An
Coimisiún
Pleanála

Direction
CD-021560-25
ABP-320009-24

The Commission decided to refuse substitute consent for the following reasons and considerations.

EXISTING WORKS DRAWING

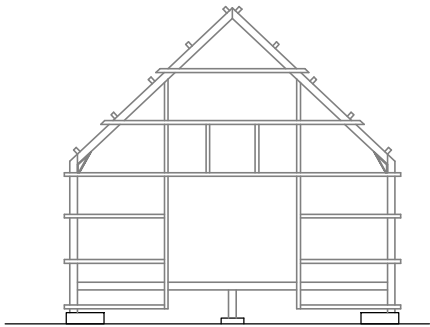
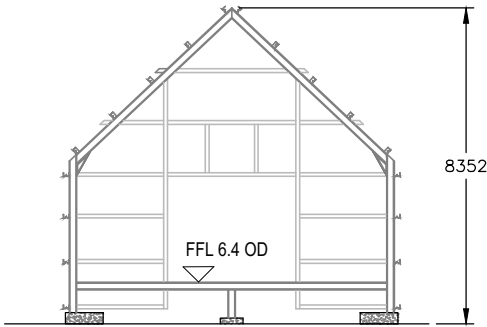
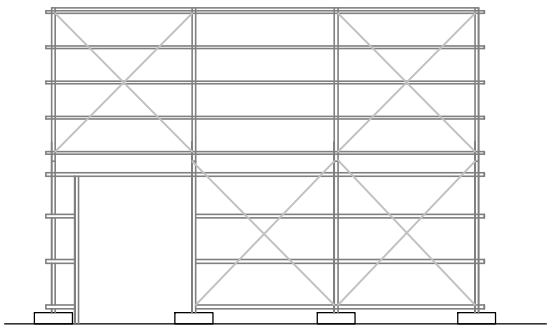
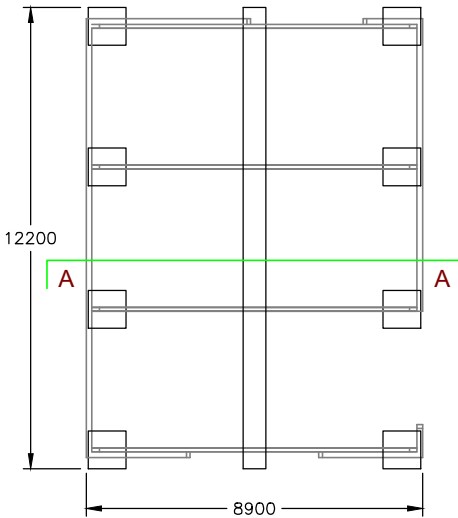
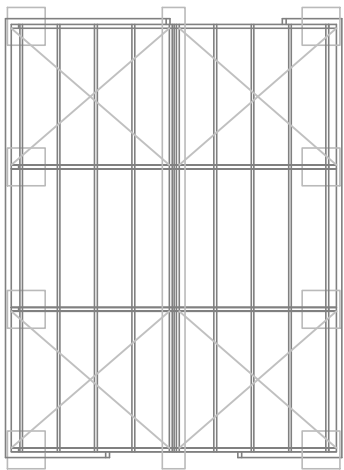
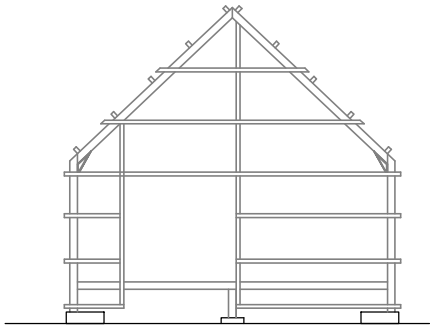
Having regard to the exposed, prominent, coastline location of the application site and the siting of the agricultural storage sheds on this exposed site, and also having regard to the scale, height, floor area and finish of the structures, it is considered that the proposed development would adversely impact on the visual amenities of this sensitive landscape, would be contrary to Policy Objective LCM 3 and Policy Objective MCD 2, would fail to comply with DM Standard 46 and would set an undesirable precedent for similar developments in the area. Furthermore, the Commission was not satisfied that the applicant had satisfactorily substantiated the case for the scale of the development proposed at this sensitive location given the nature of the agribusiness as described in application documentation and the Commission did not consider that the development constituted a family farm business on this site. The proposed development would, therefore, be contrary to the proper planning and sustainable development of the area.

**Proposed completion of Main
agricultural building.**

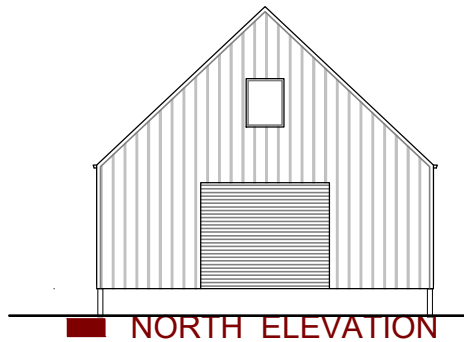
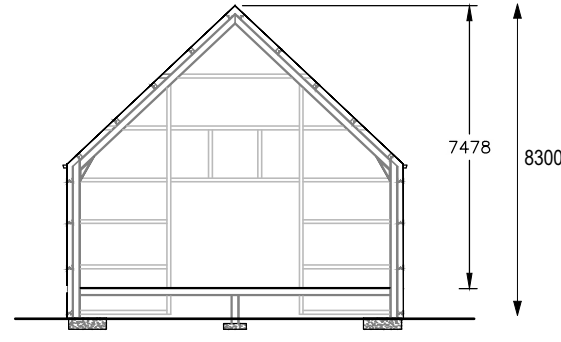
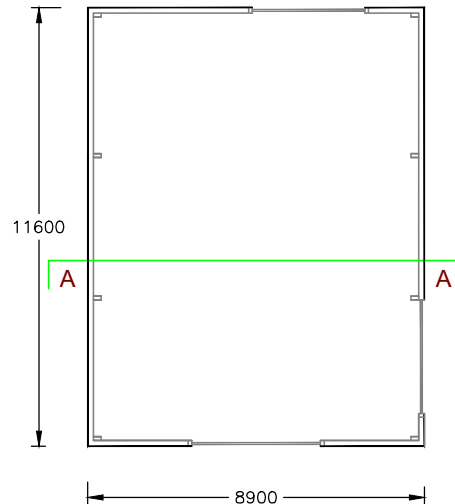
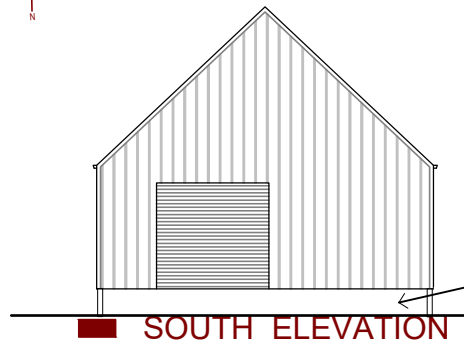
In deciding not to accept the Inspector's recommendation to grant substitute consent, the Commission considered that the structures would adversely impact on the visual amenities of this exposed, sensitive coastal location which the planning authority seeks to protect as indicated in the statutory development plan for the area. The Commission was not satisfied that the applicant had substantiated the agribusiness case for the structures at this location and a grant of substitute consent would set an undesirable precedent for similar development in this area that has a high sensitivity to change as indicated in the statutory development plan. The Commission agreed with the planning authority's concerns relating to the principle of the development at this location in the absence of a substantiated case and
